DEPARTMENT OF COMMUNITY SERVICES

Subject: Eagleview Subdivision Filing No. 1 Final Plat – (SF-22-038)

The Park Operations Division of the Community Services Department has reviewed the Eagleview Subdivision Filing No. 1 Final Plat development application and has the following **preliminary** comments of behalf of El Paso County Parks. This application and the following comments and recommendations will be presented to the Park Advisory Board for endorsement on February 8, 2023:

EAGLEVIEW  
A PORTION OF THE NORTHWEST QUARTER OF SECTION 26, TOWNSHIP 12 SOUTH,  
RANGE 65 WEST OF THE 6th P.M., EL PASO COUNTY, COLORADO

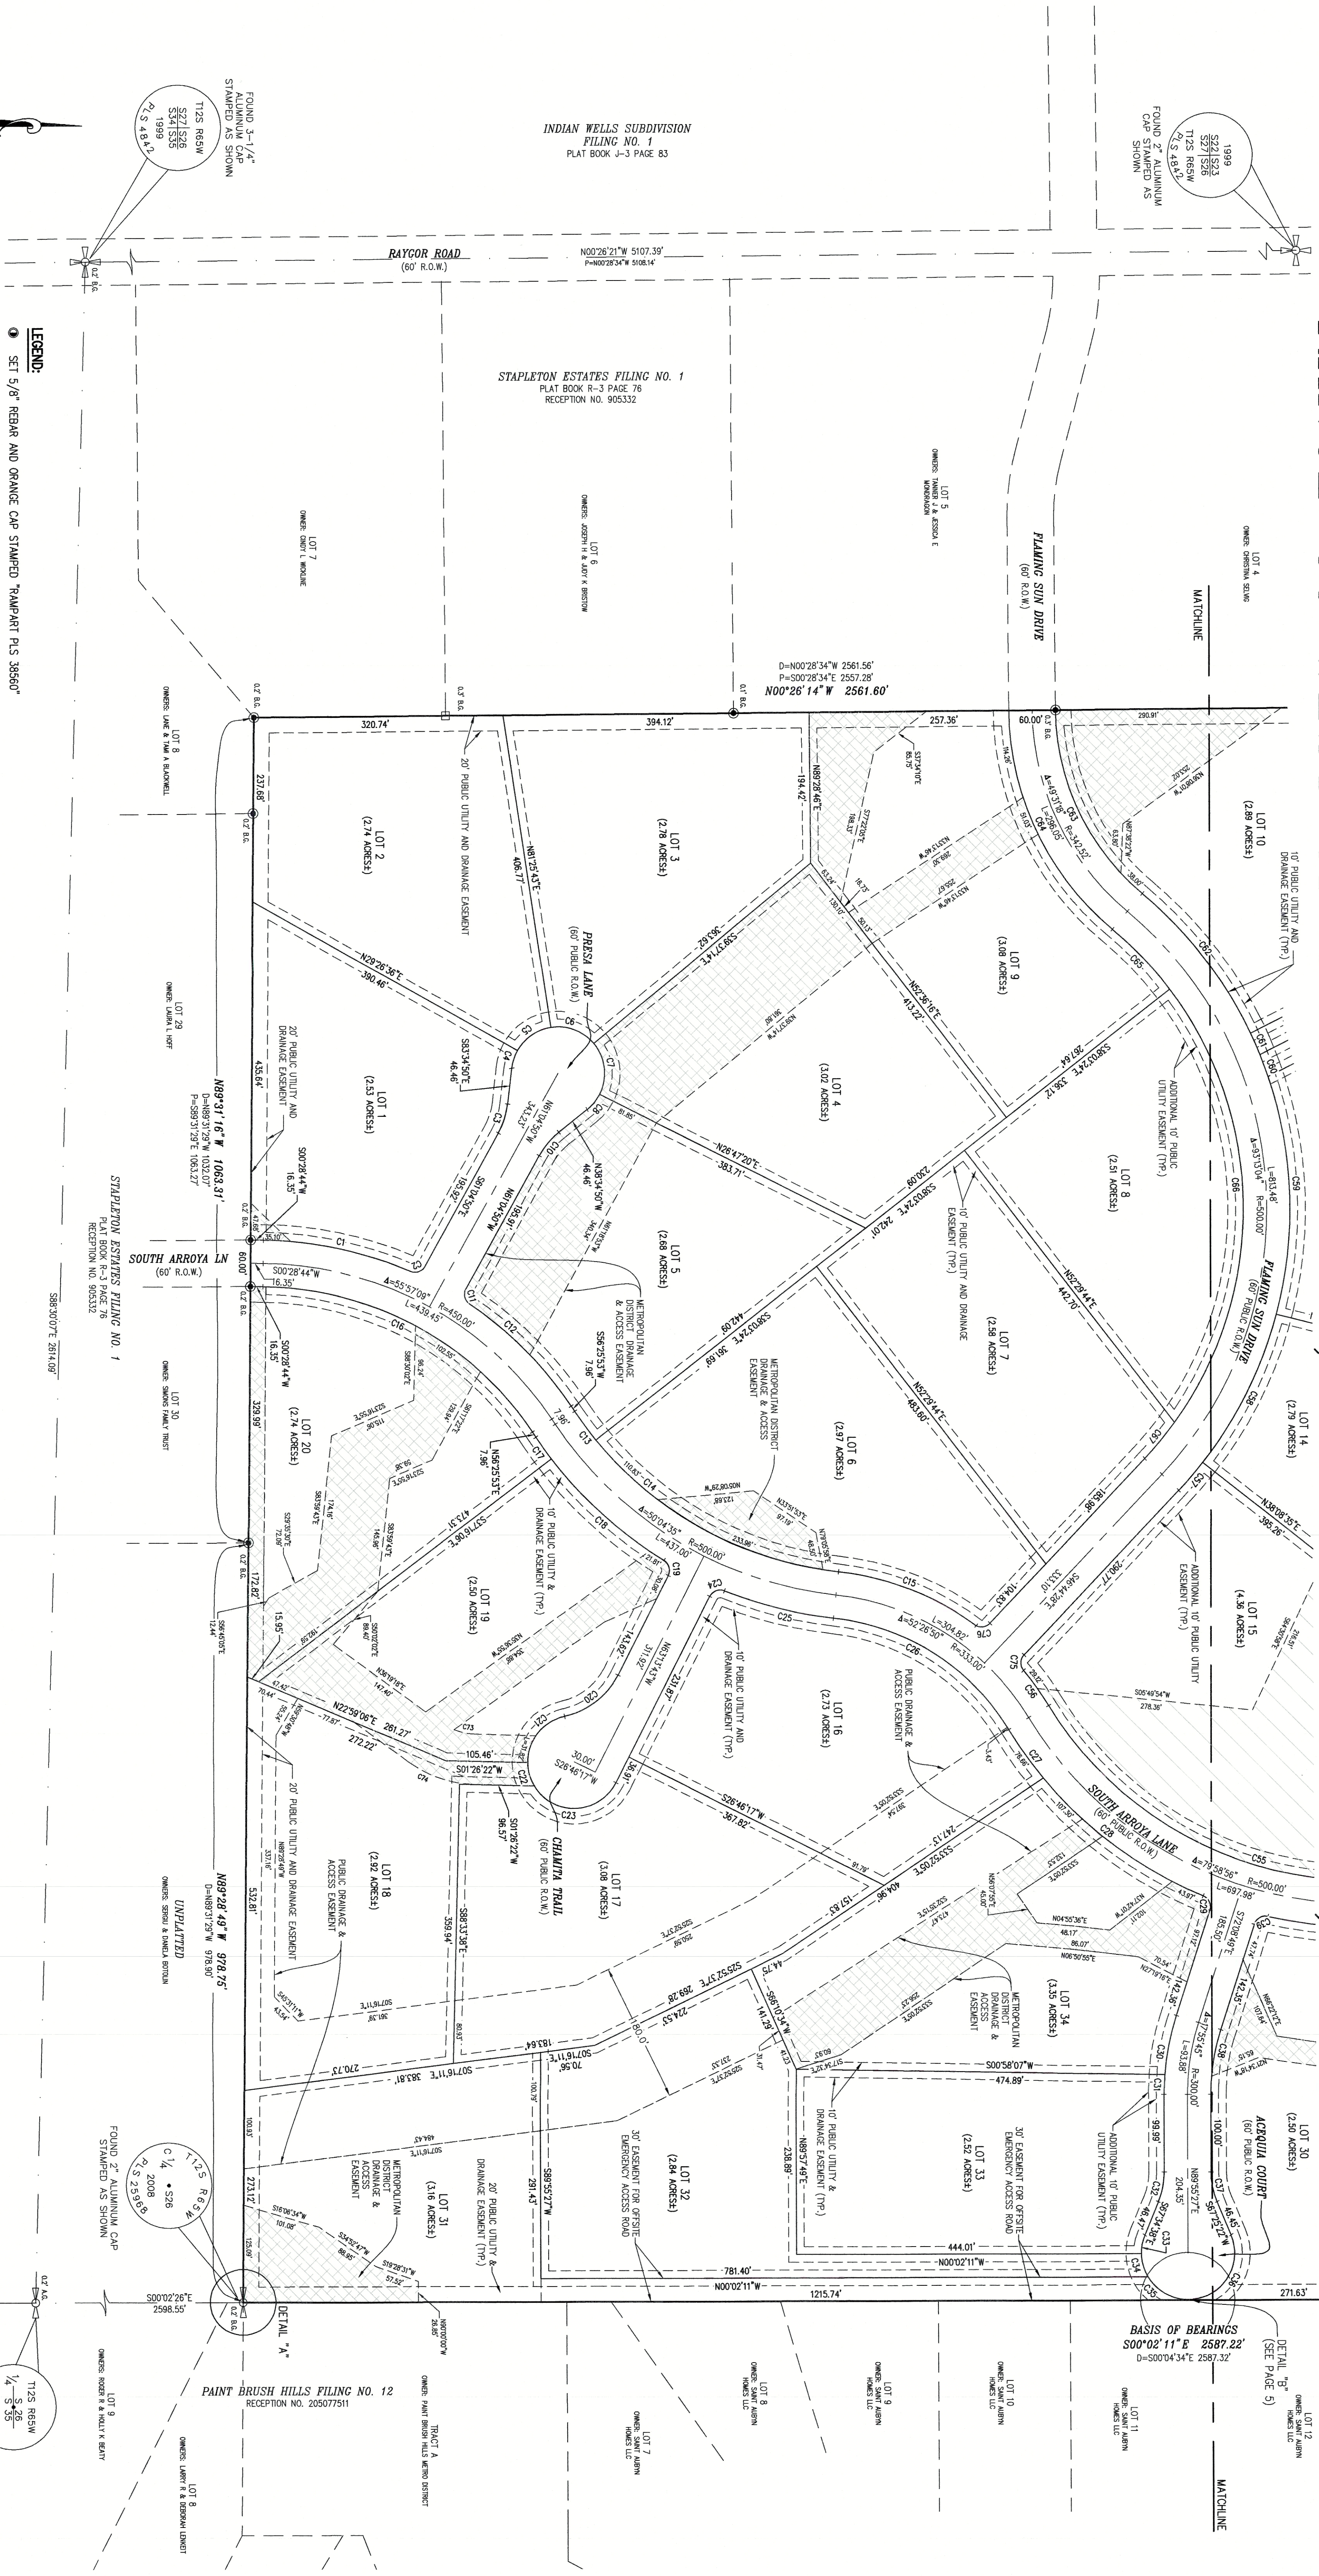
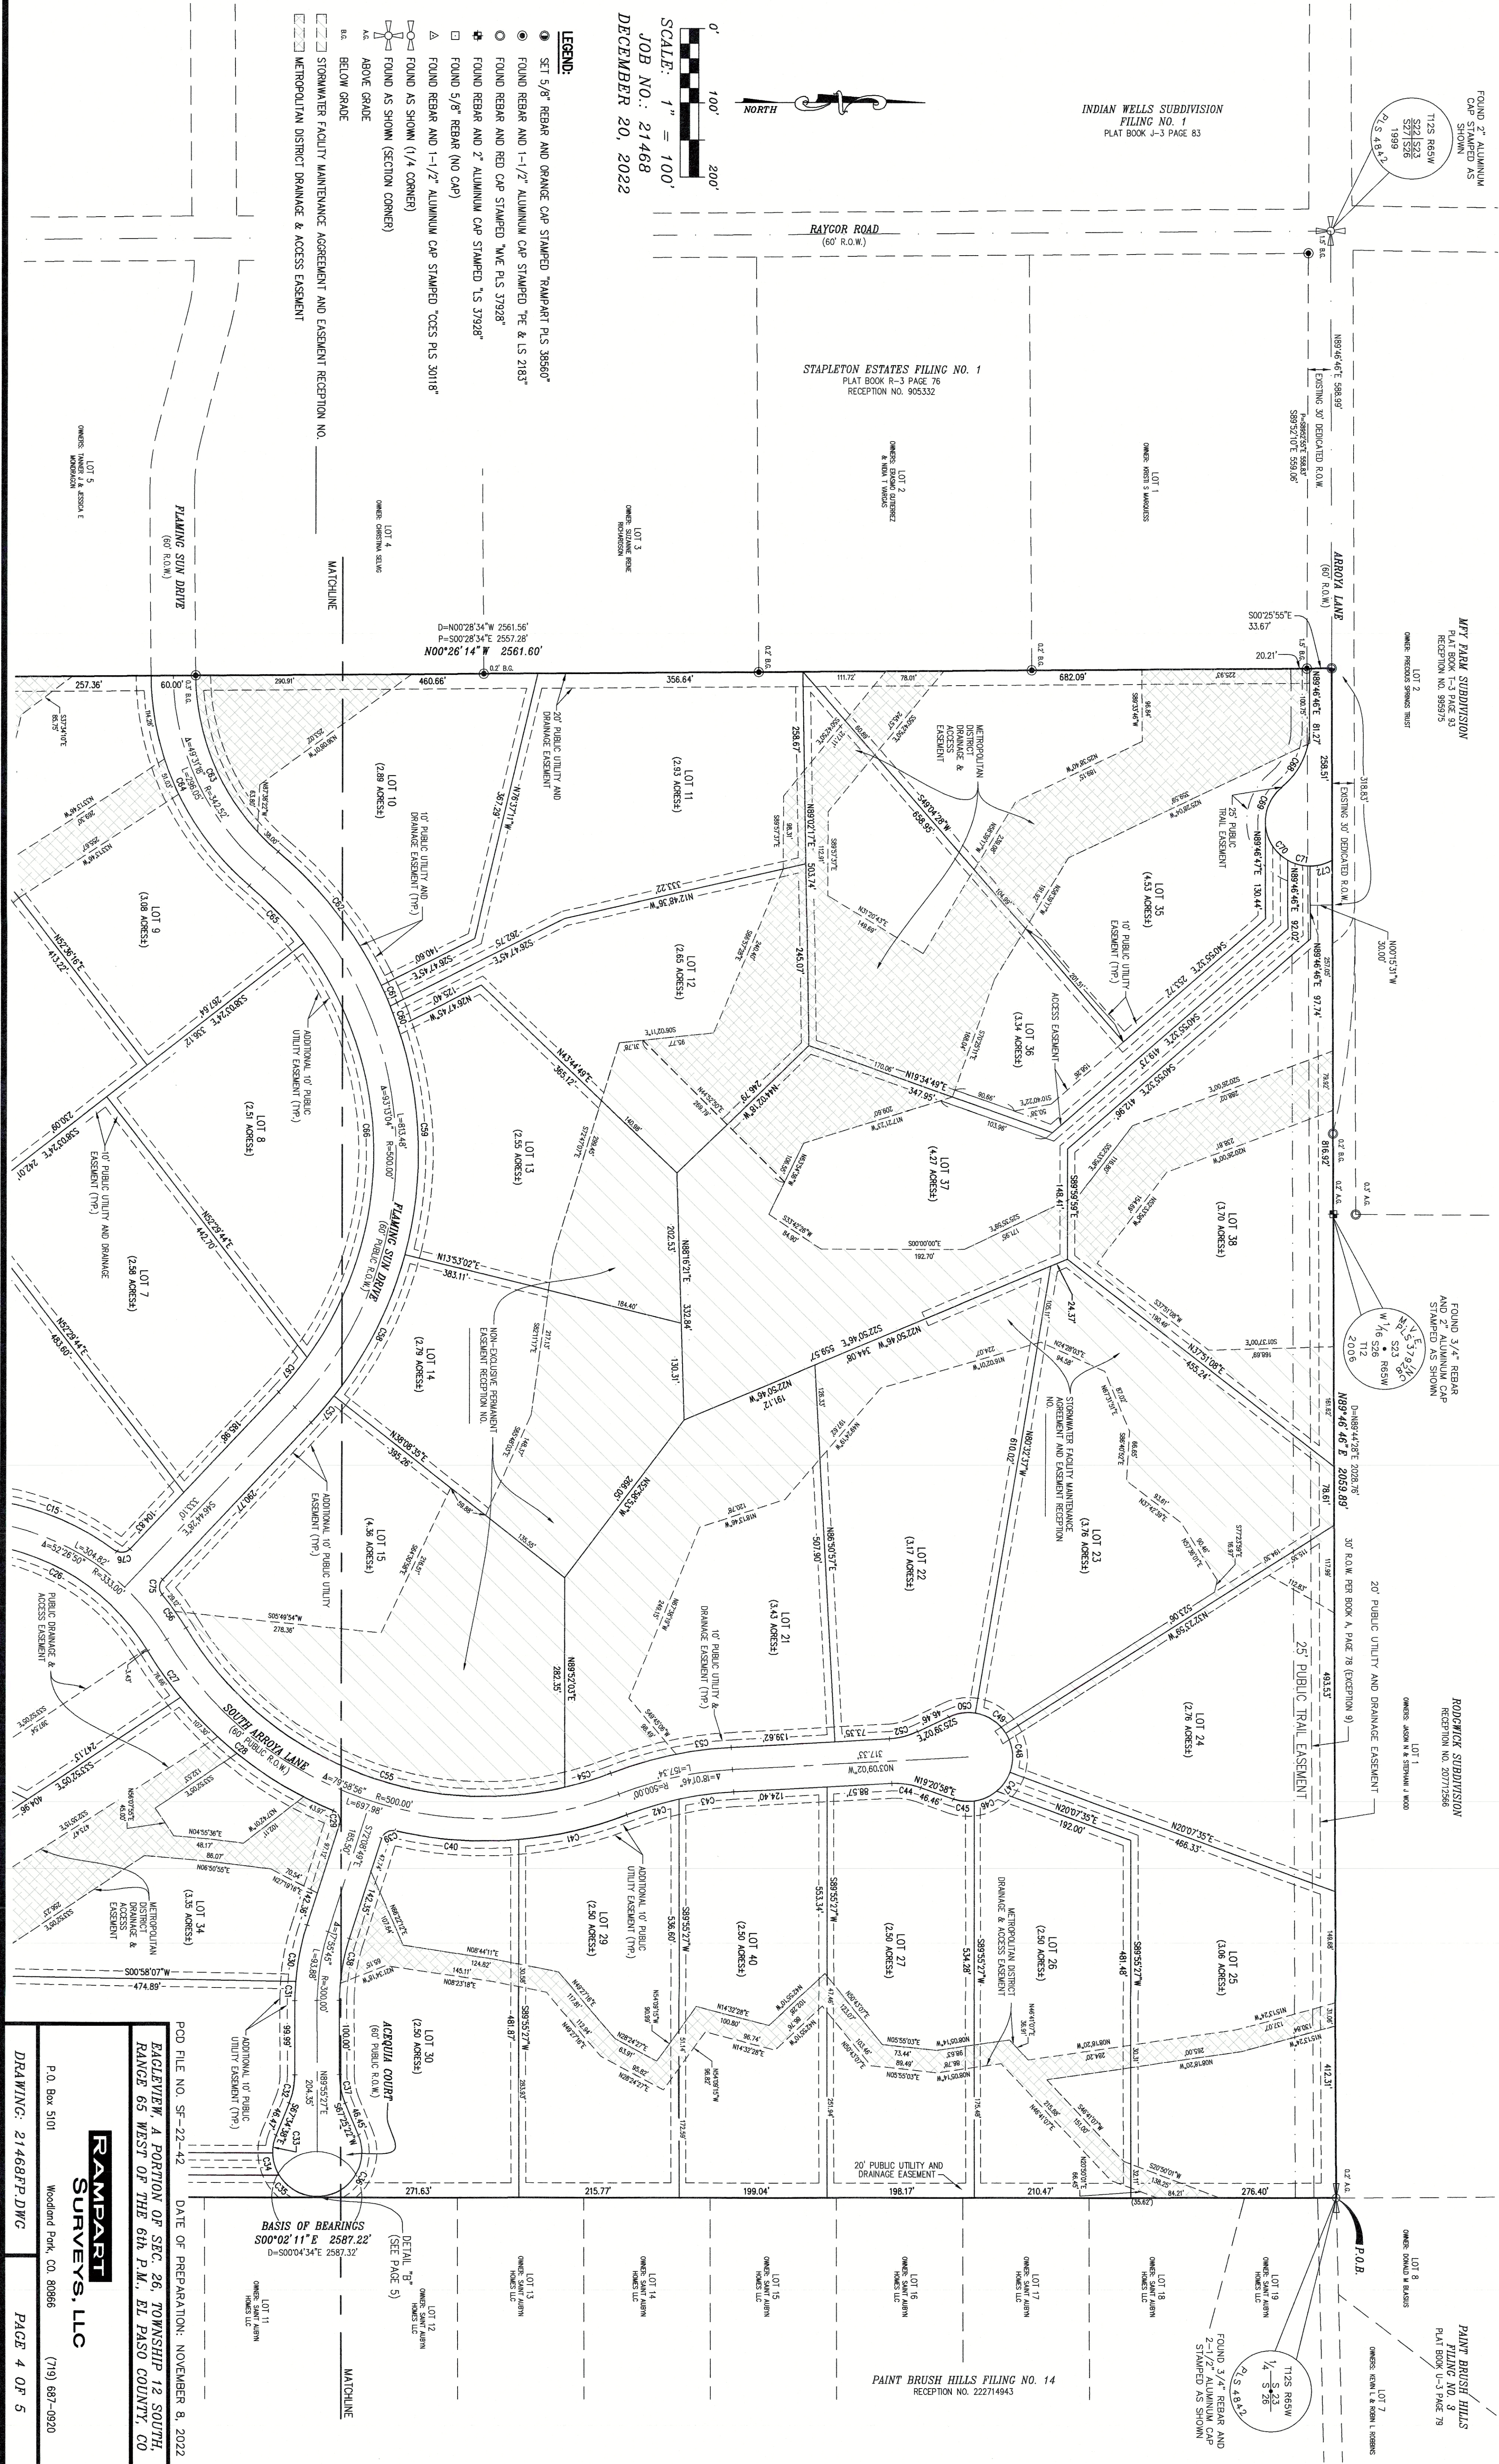
Although shown properly on the approved Preliminary Plan, the applicant omitted the Arroyo Lane Primary Regional Trail easement from this Final Plat. This trail runs east-west across the northern portion of the project area and, as mentioned above, is present in the Trails Master Plan portion of the 2022 Parks Master Plan and is an important proposed regional trail connection between Vollmer Road and Meridian Ranch. Trail easements have been established at The Retreat at TimberRidge and Paint Brush Hills, located to the west and east, respectively.

Currently, this trail easement is only shown on Page 4 of the submitted Construction Documents. Therefore, staff recommends that a 25' trail easement be designated along the northern edge of Eagleview Estates, outside of the proposed Arroyo Lane right-of-way, which will allow for the construction, maintenance, and public access of the Arroyo Lane Primary Regional Trail. This easement shall be shown on the Final Plat and included in the Plat Easement Notes prior to the recording of Filing No. 1 Final Plat.

The Park Advisory Board recommends that the Planning Commission and the Board of County Commissioners include the following conditions when considering and/or approving the Eagleview Subdivision Filing No. 1 Final Plat: (1) designate and provide to El Paso County a 25-foot trail easement along the northern boundary of Eagleview Subdivision, outside of the Arroyo Lane right-of-way, that allows for the construction, maintenance, and public access of the Arroyo Lane Primary Regional Trail, and dedicate the aforementioned easement to El Paso County prior to the recording of this Final Plat; (2) fees in lieu of land dedication for regional park purposes in the total amount of \$17,480 will be required at the time of the recording of this Final Plat.
